Subject: Retail Ranch Filing No. 1 – 2nd Review

The purpose of this letter is to respond to review agency responses to the above named development application. Responses to comments are shown in **RED** below the agency comment.

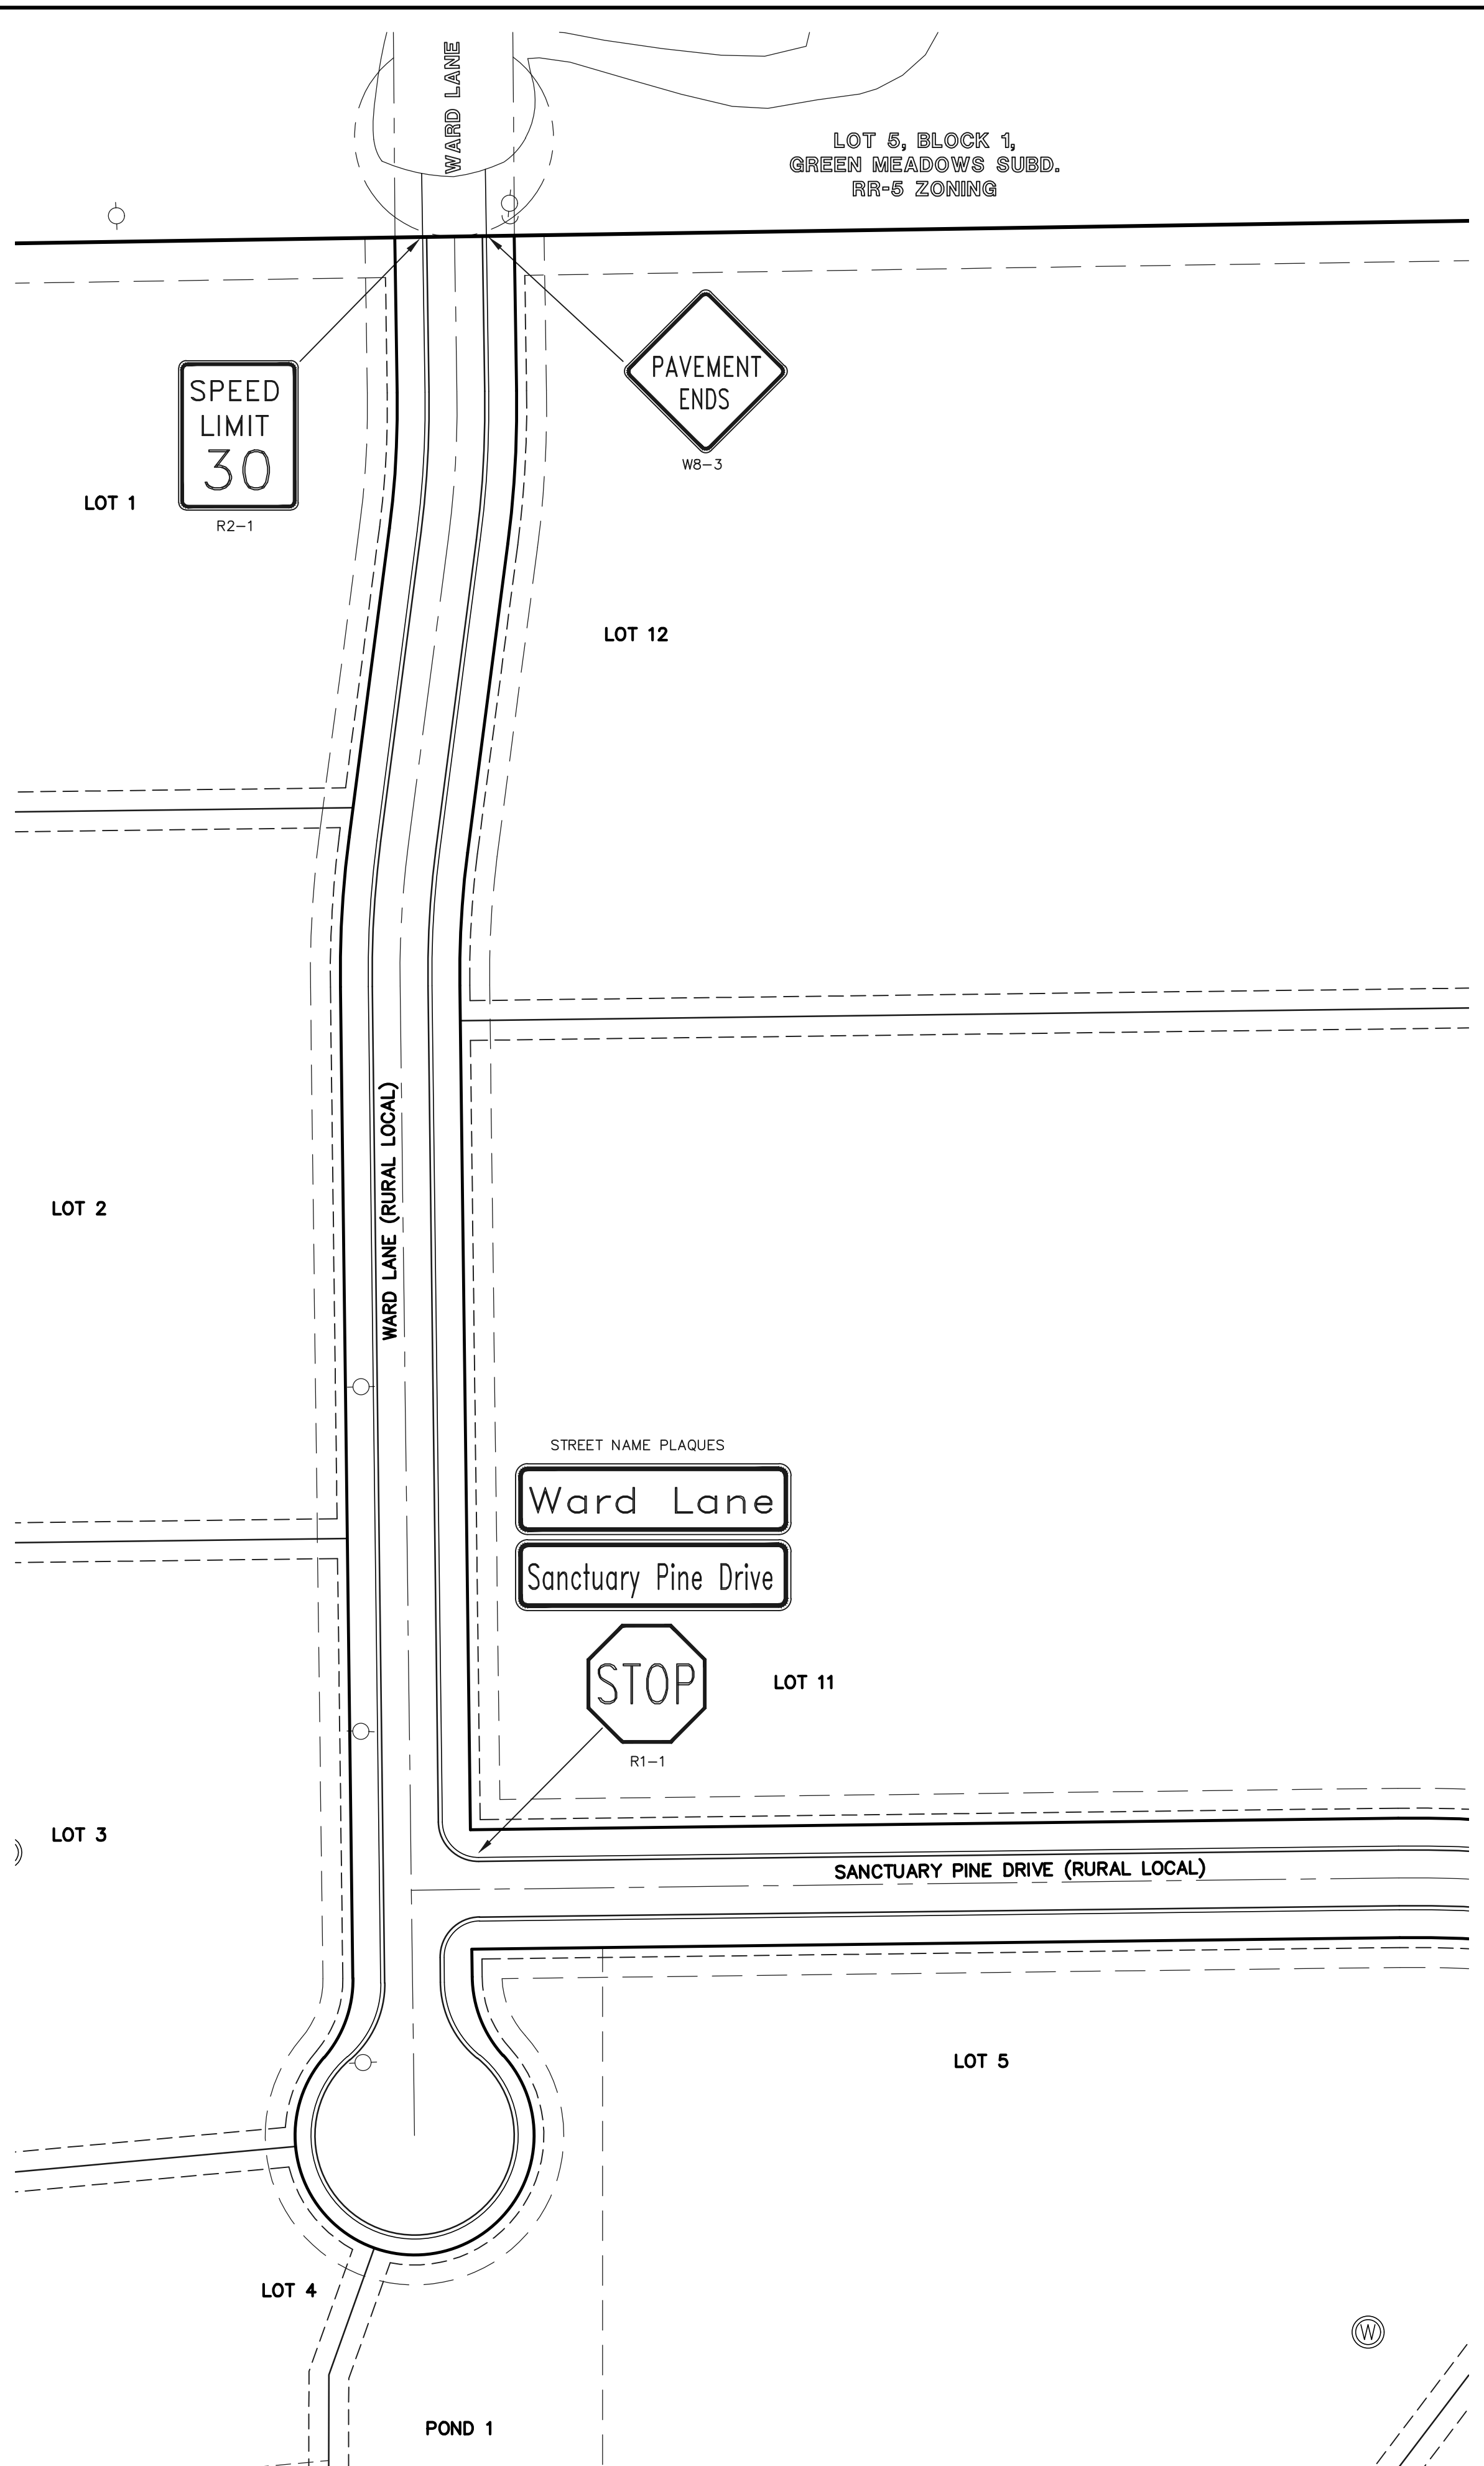
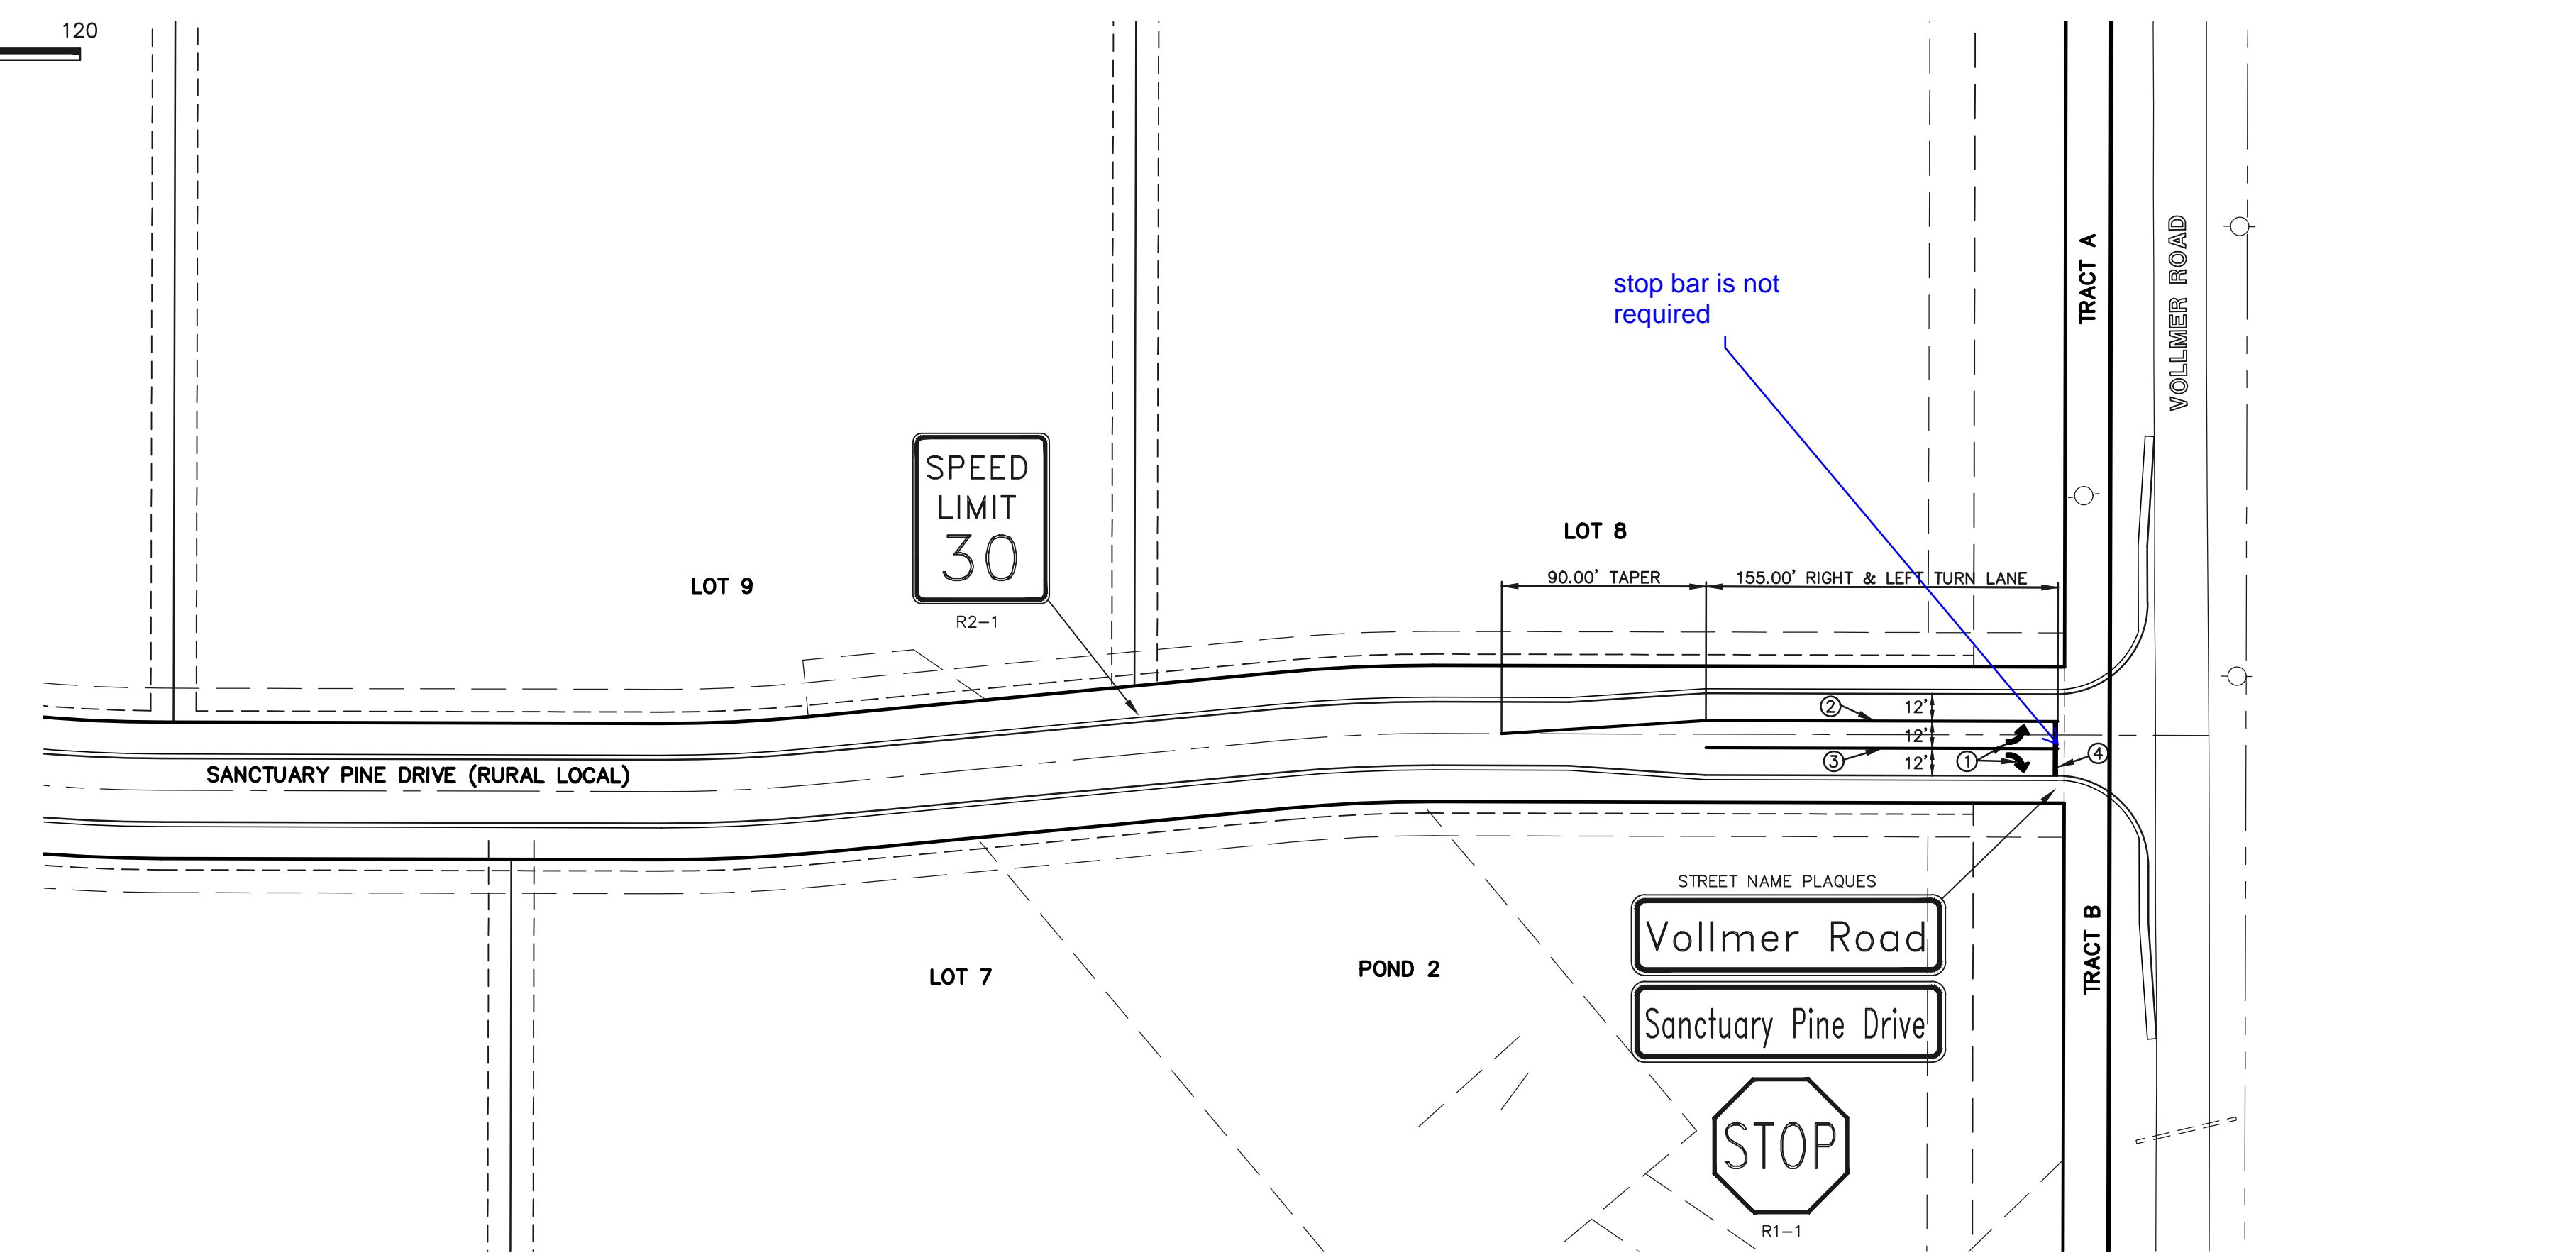
4. Provide a signing and striping plan. ~~Address the following areas:~~ **Resolved; see redlines. Addressed. See revised plans**
5. Ensure that the following issues are adequately addressed in regard to roadside ditches and FSD BMP outfalls:
